Subject: 2026/90310 at location land off, Sunny View, White Lee, Batley, WF17 8FP

Please see ecological commentary below

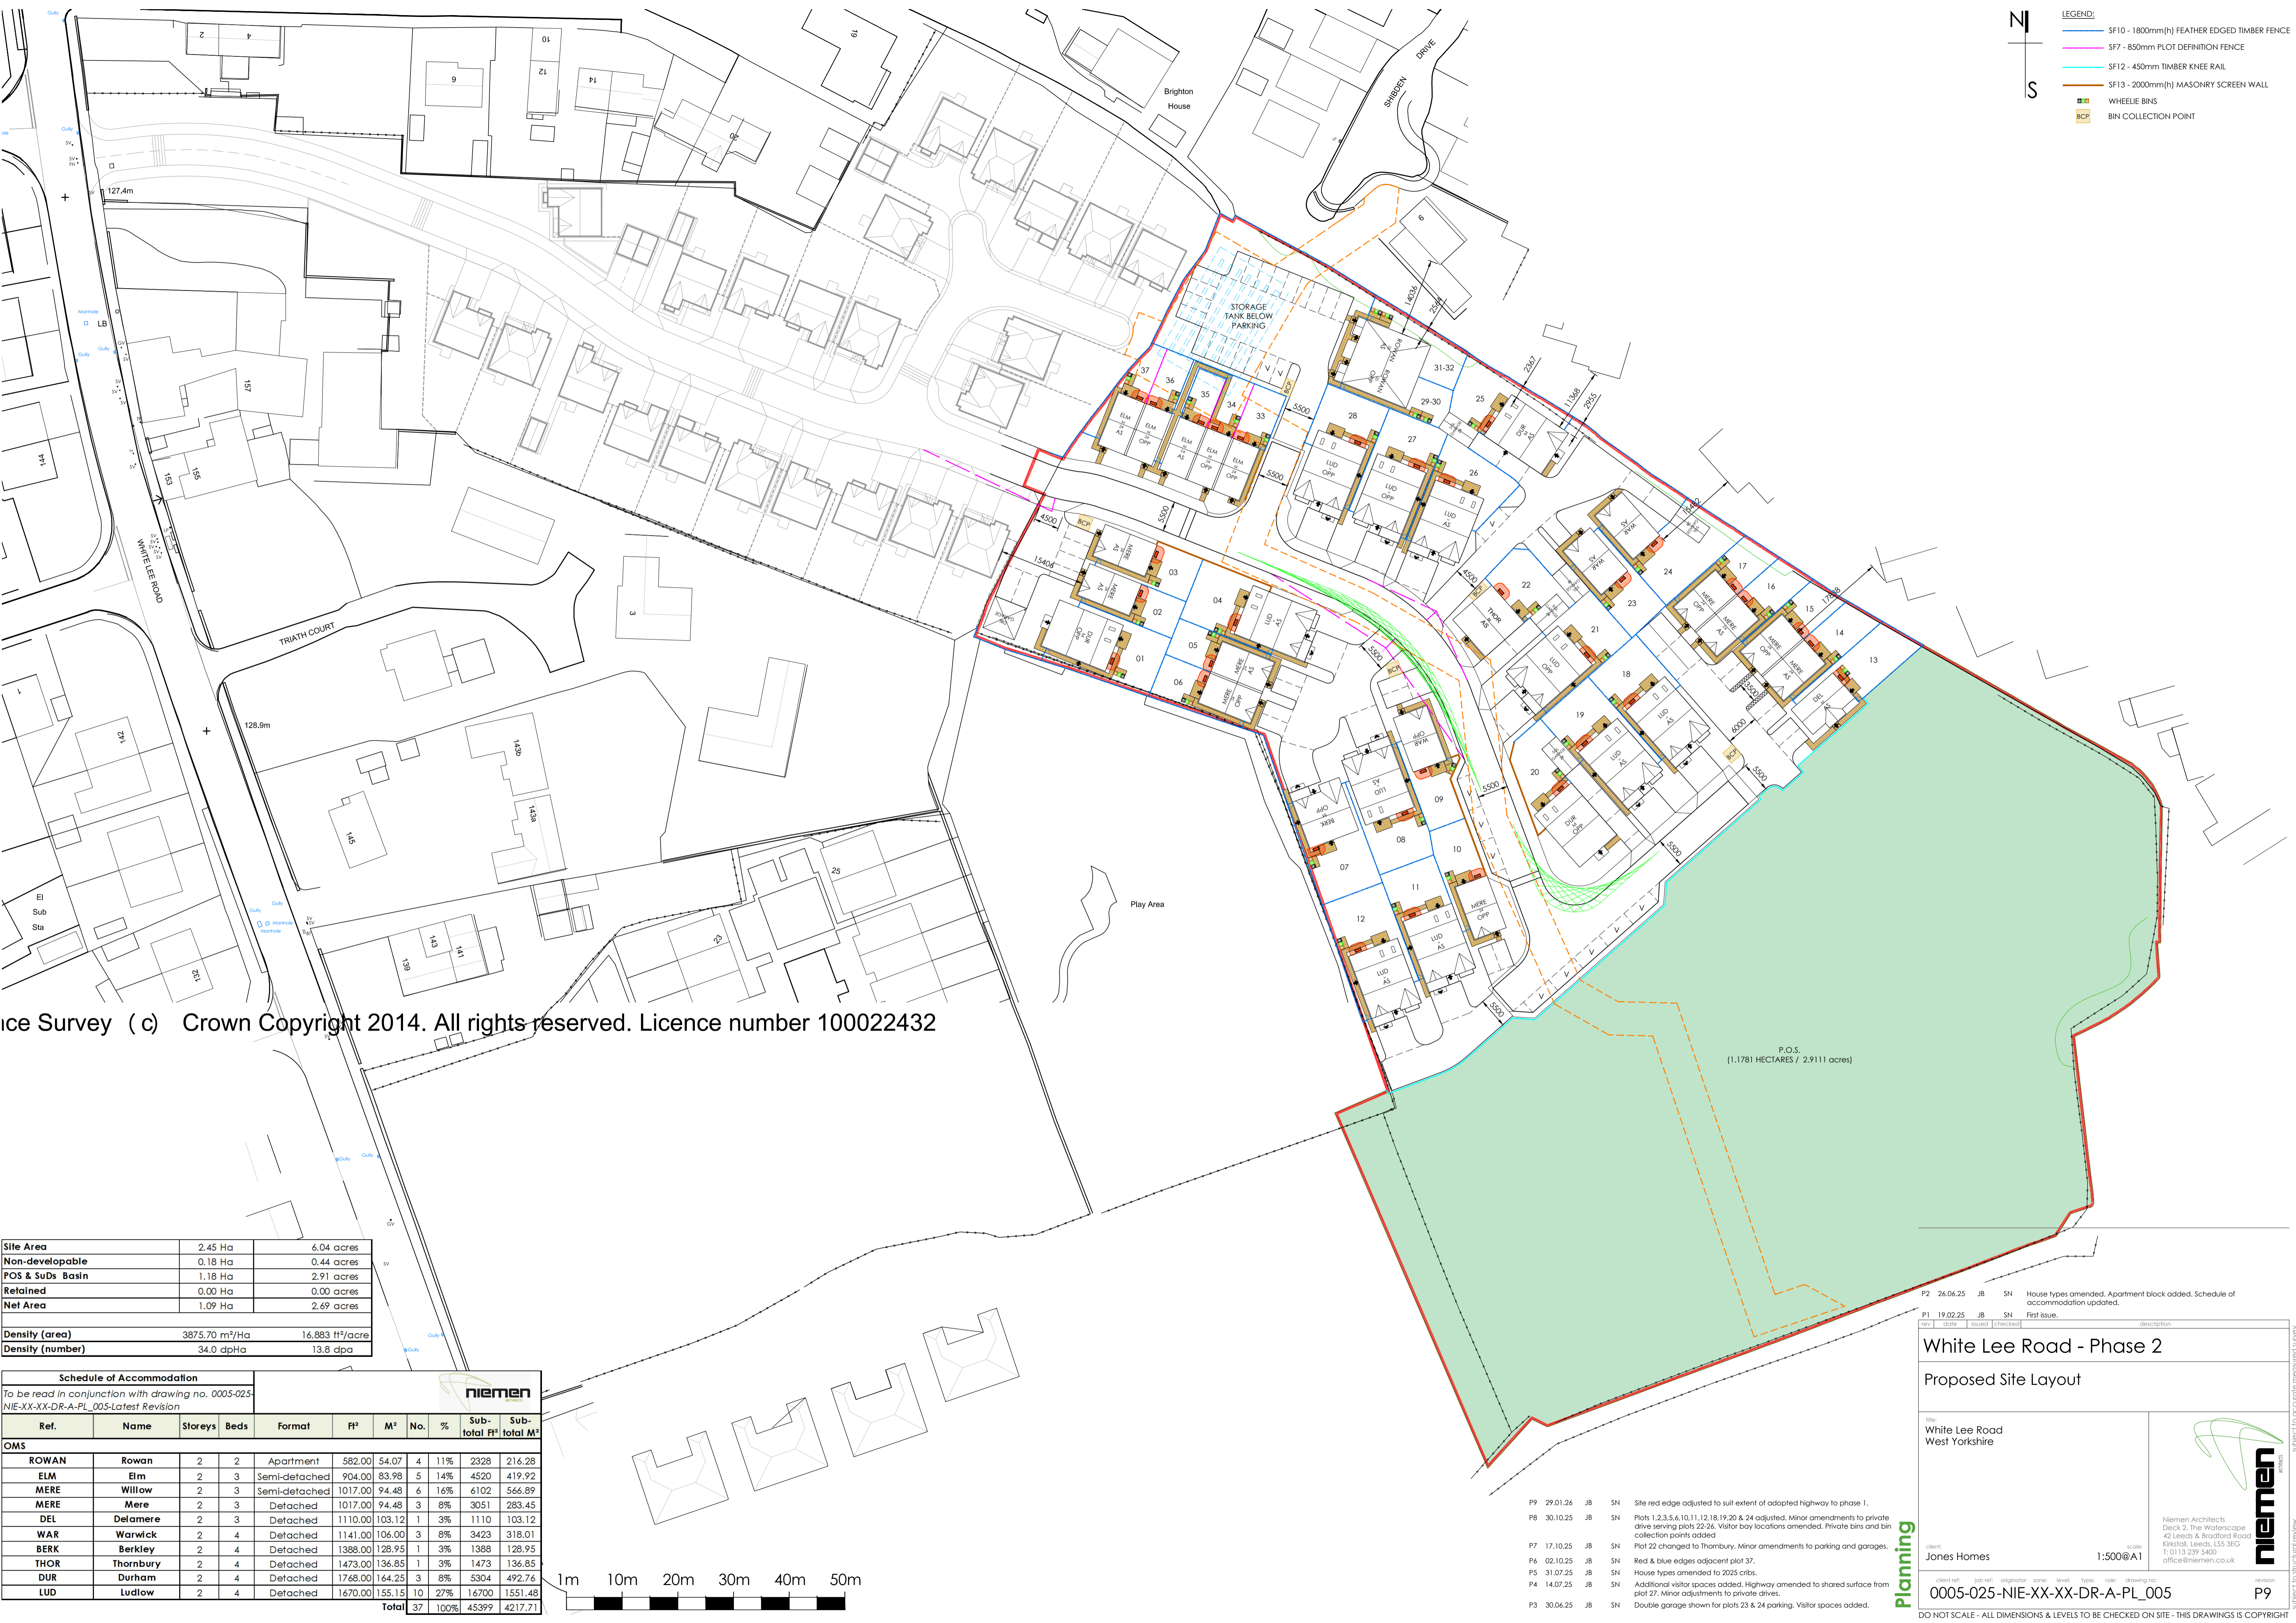
It is noted that an Urban Greenspace Review document has been provided (Pegasus group, Feb 2026); however, this and the EclA and the Proposed site layout (nieman, June 2025) does not display attenuation ponds, ditches, etc. to make up for lost run off area for the development itself and the surround residential areas and to encourage further wildlife.
